Re Architectural Design Statement - Response to SSD submissions

Further to the receipt of the submissions to the SSD for Shore Physical Education Centre we have the following responses.

PLAN - 21 MARCH - 12:00 NOON -
SHADOW CAST BY 12M HIGH COMPLIANT

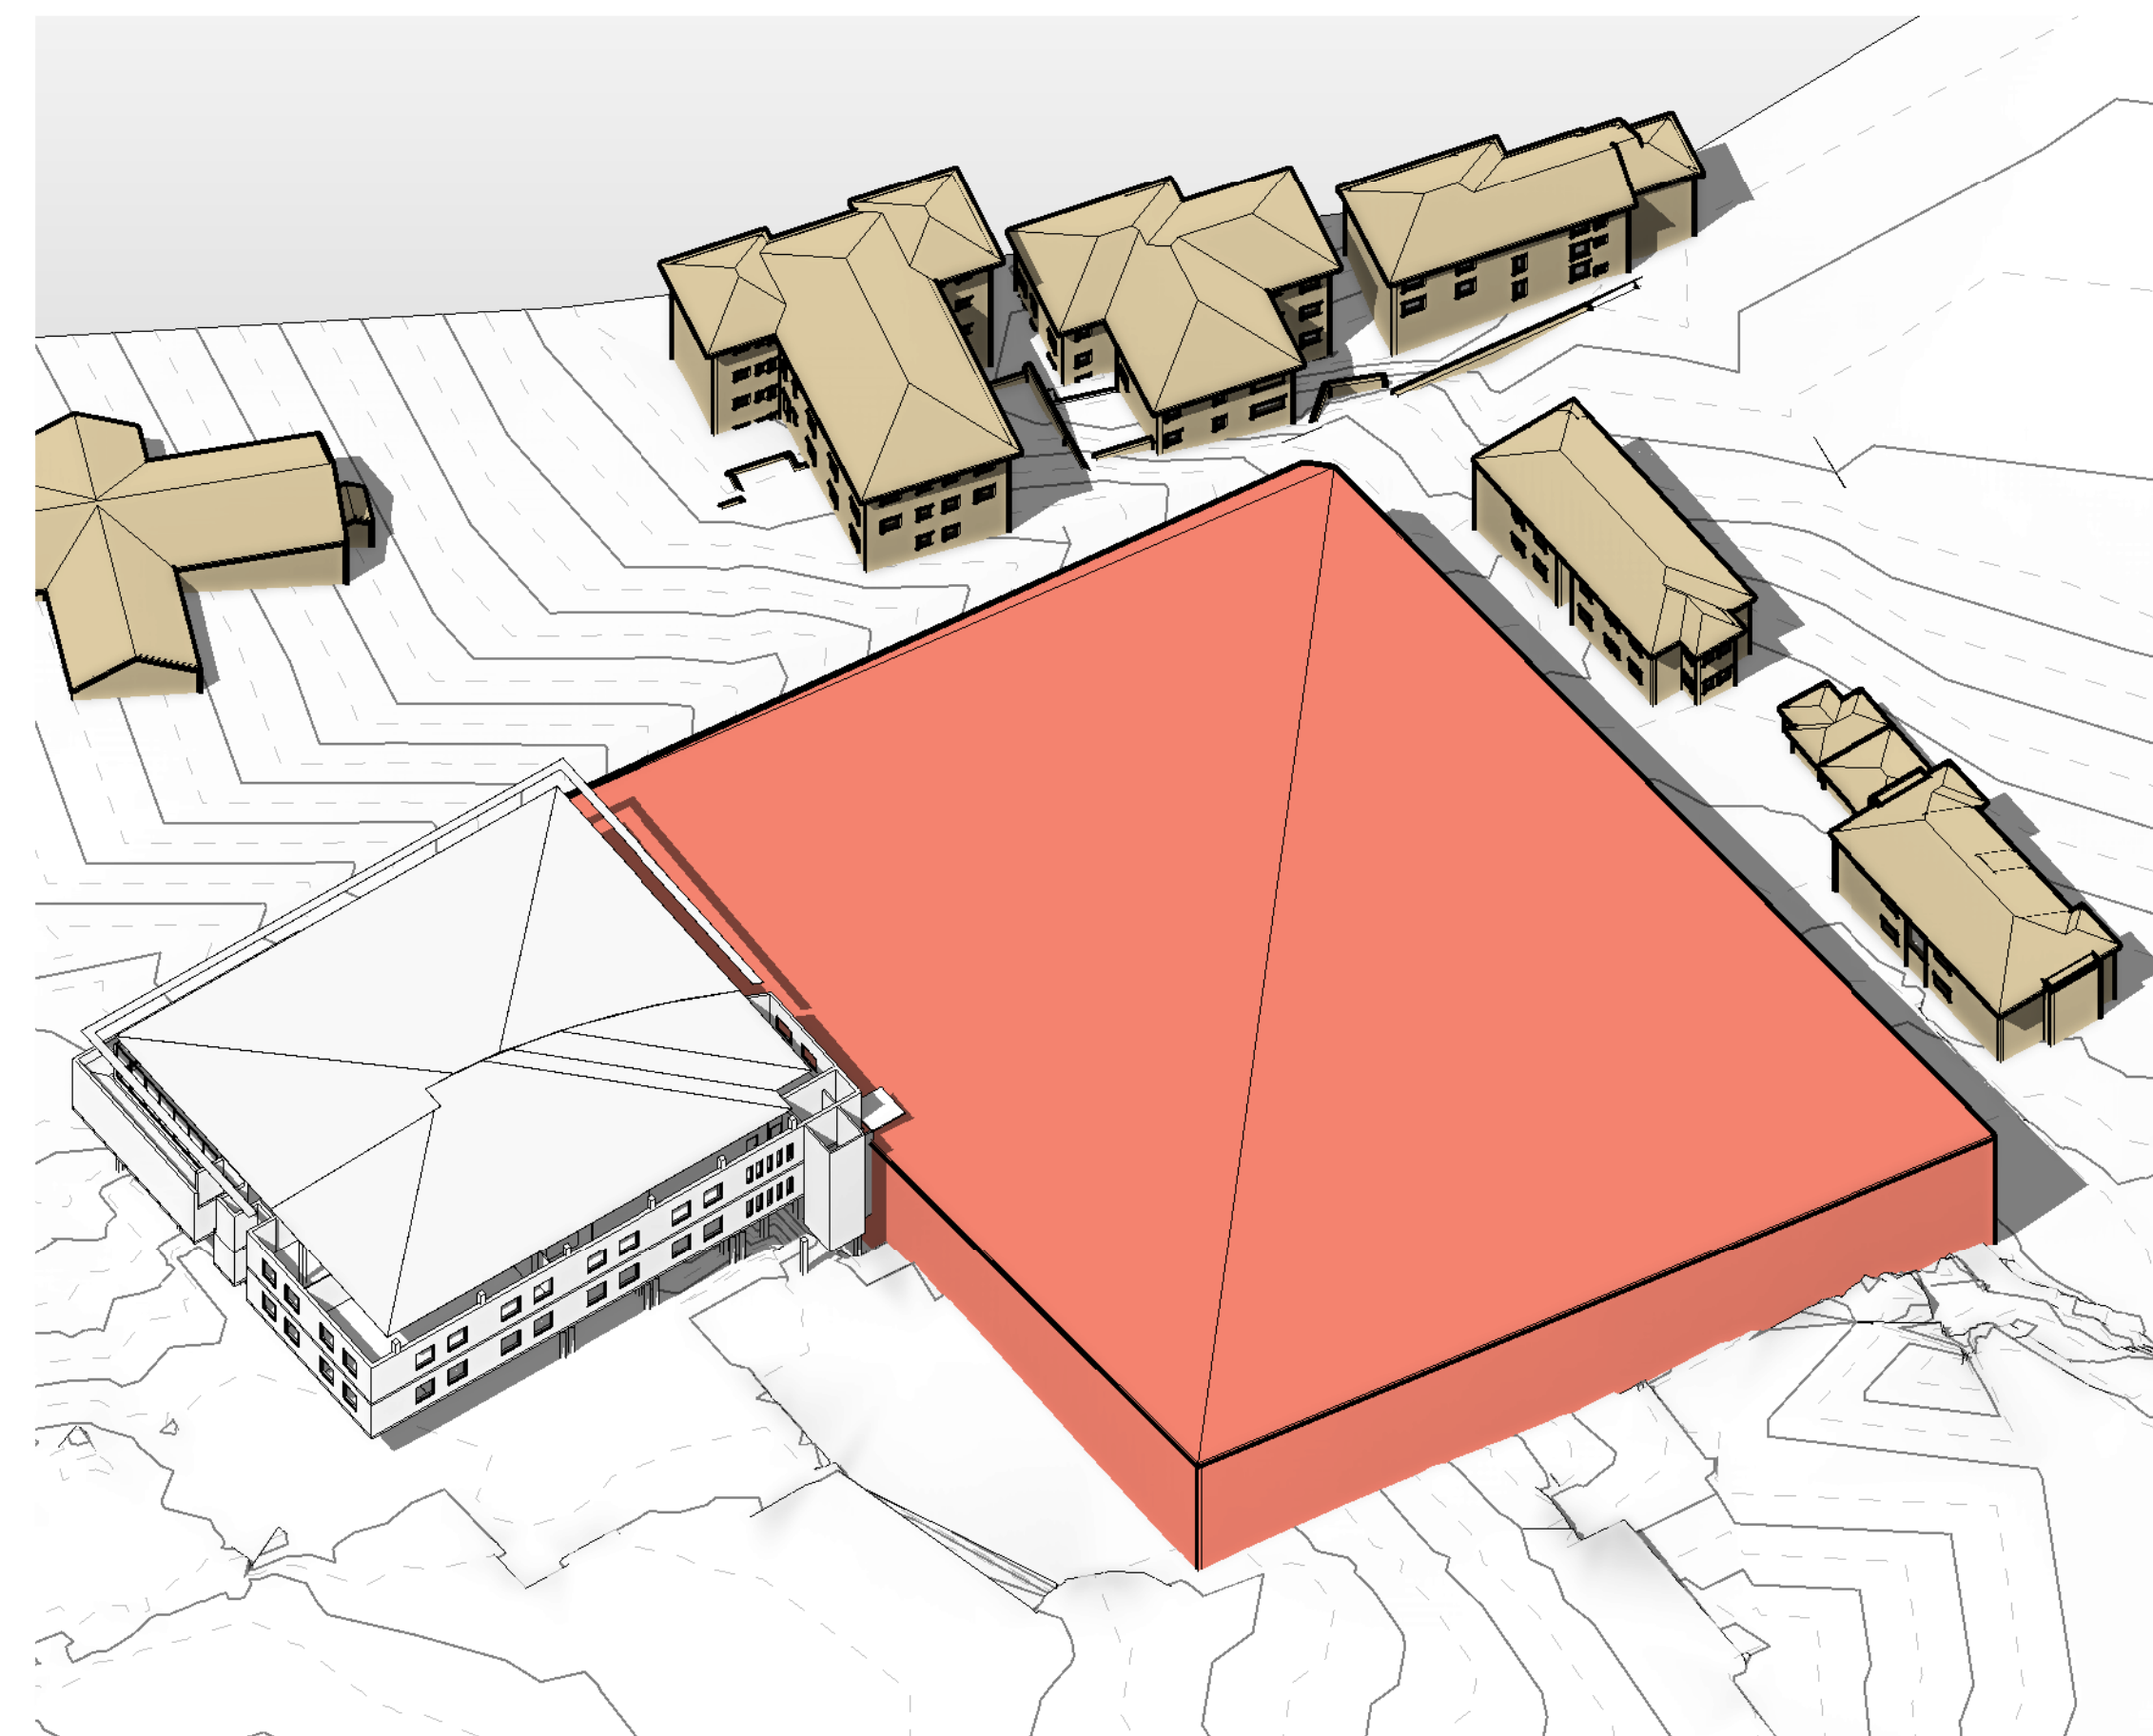
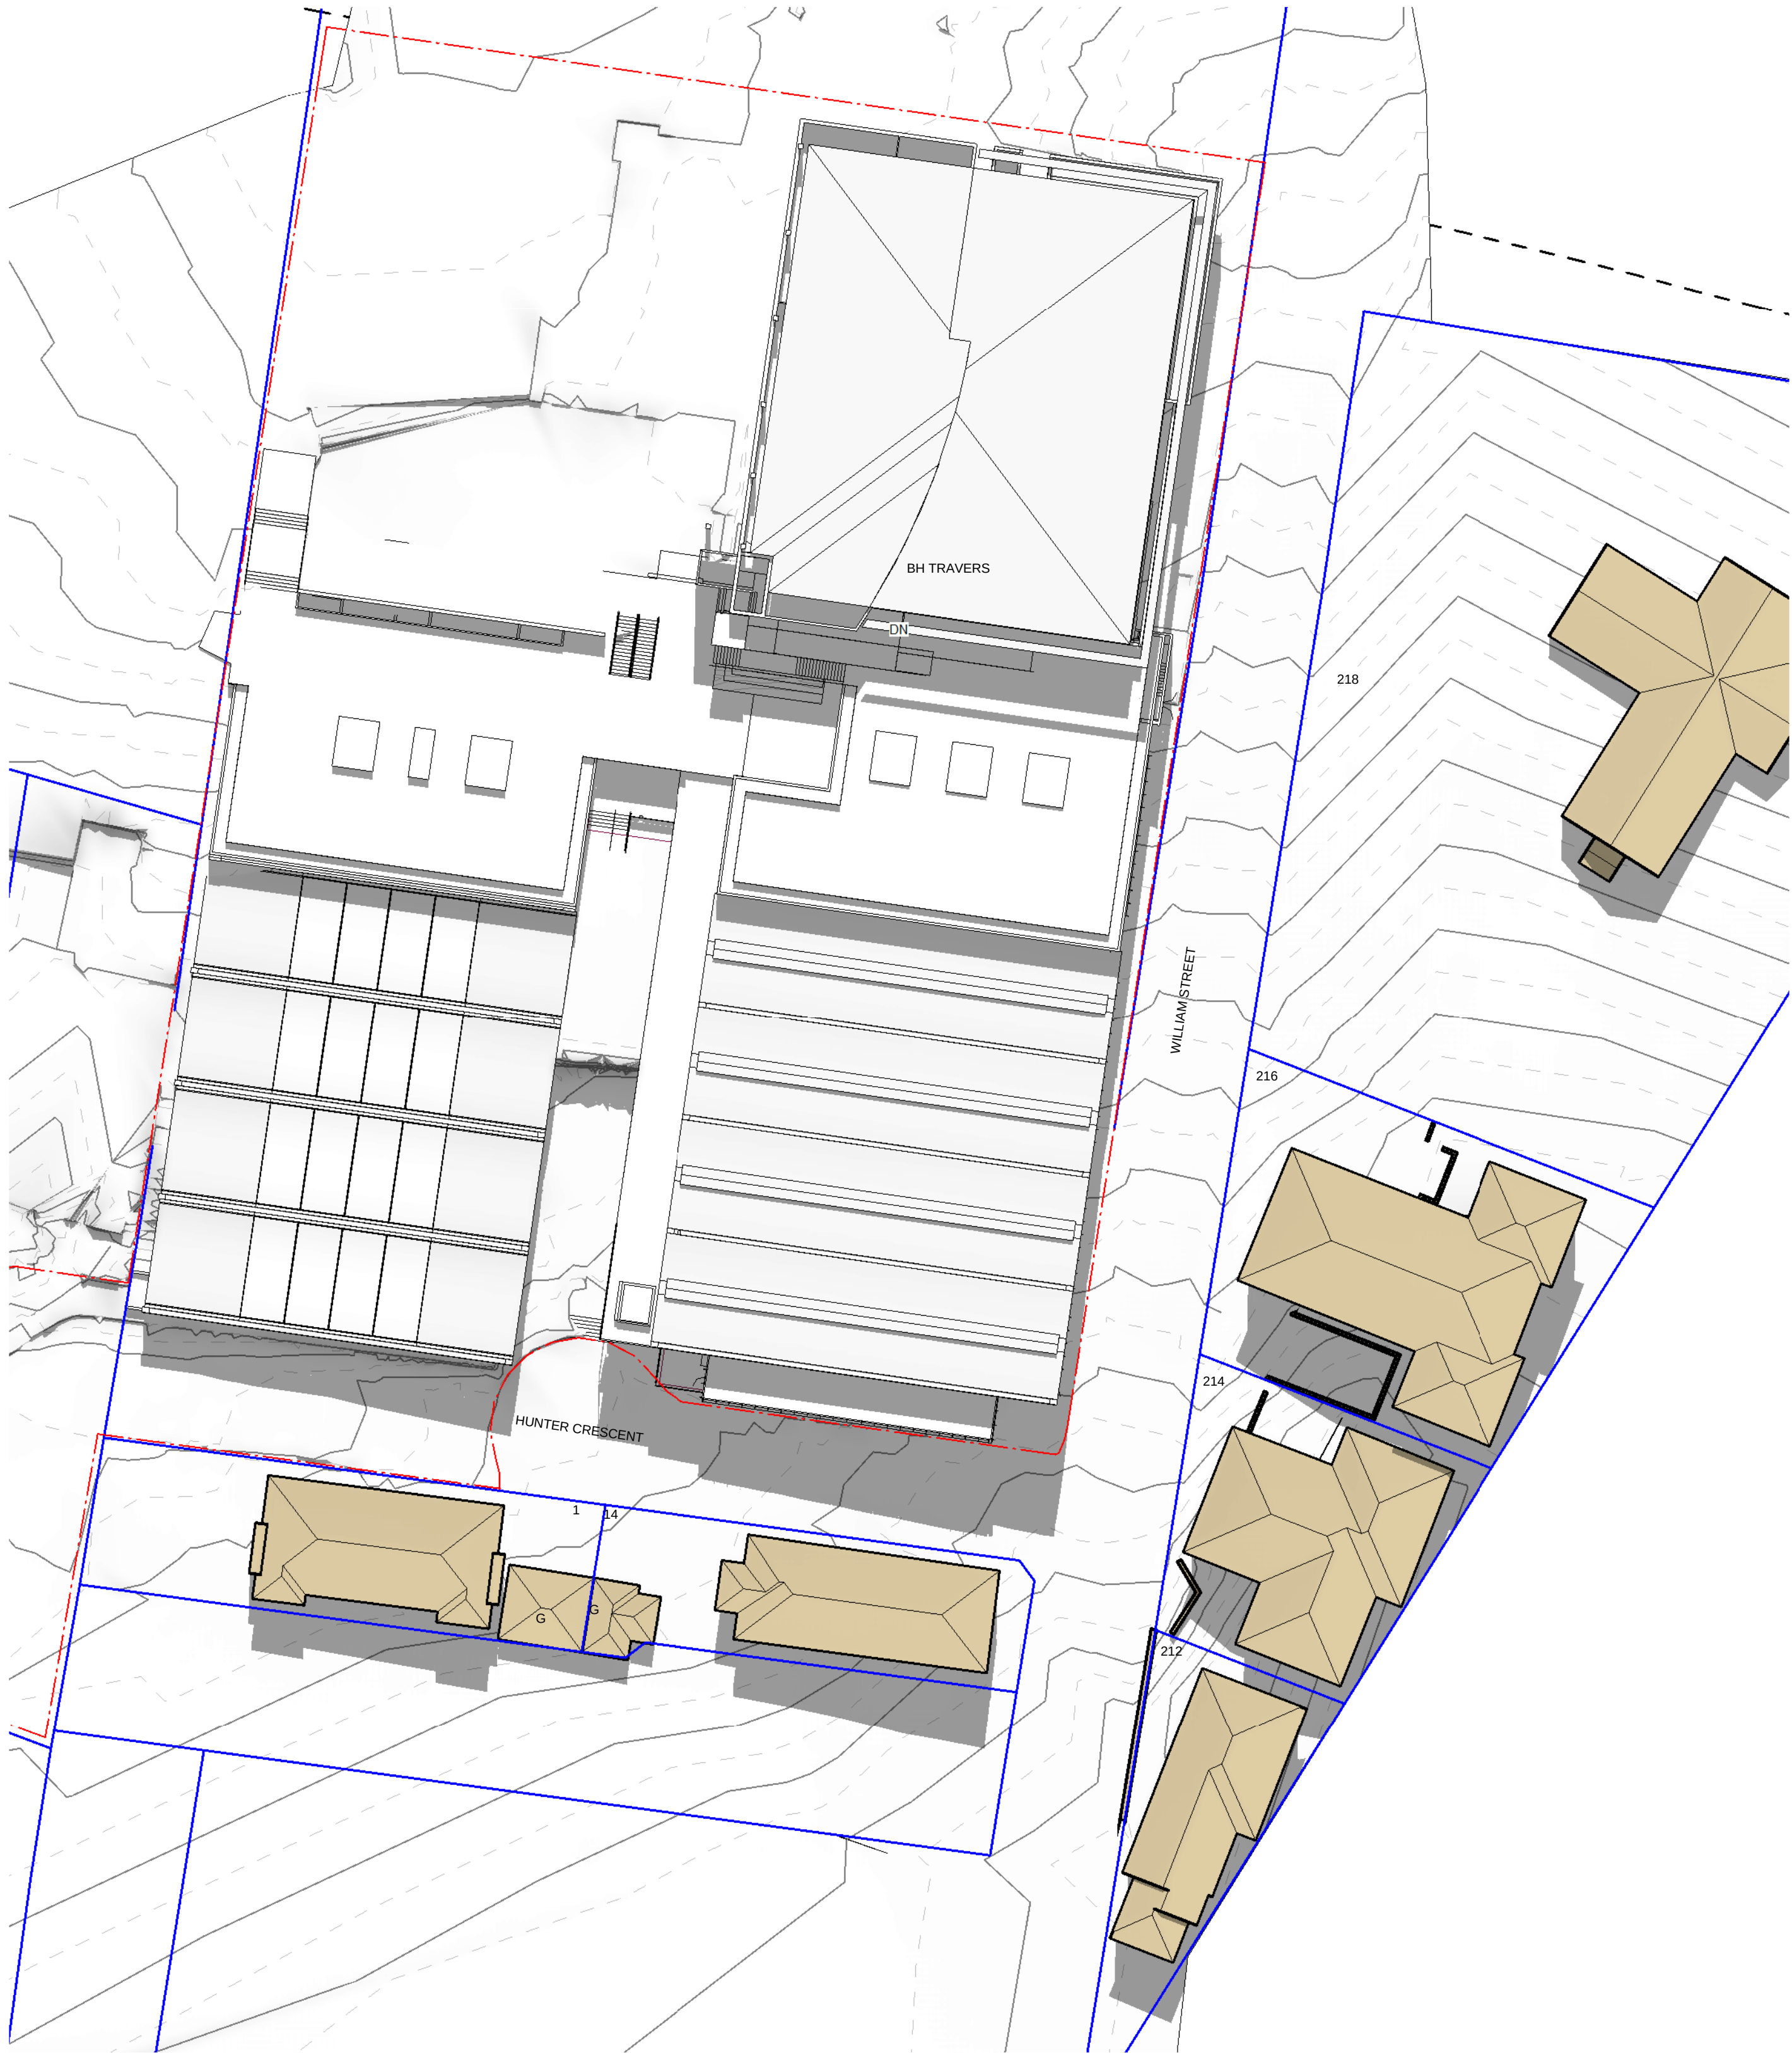
The shadow diagrams provided in the SSD submission provide evidence of the windows to habitable rooms that are impacted by overshadowing, with a comparison with those of a compliant height development. There is little difference between the compliant height development shadows and the proposed SPEC.
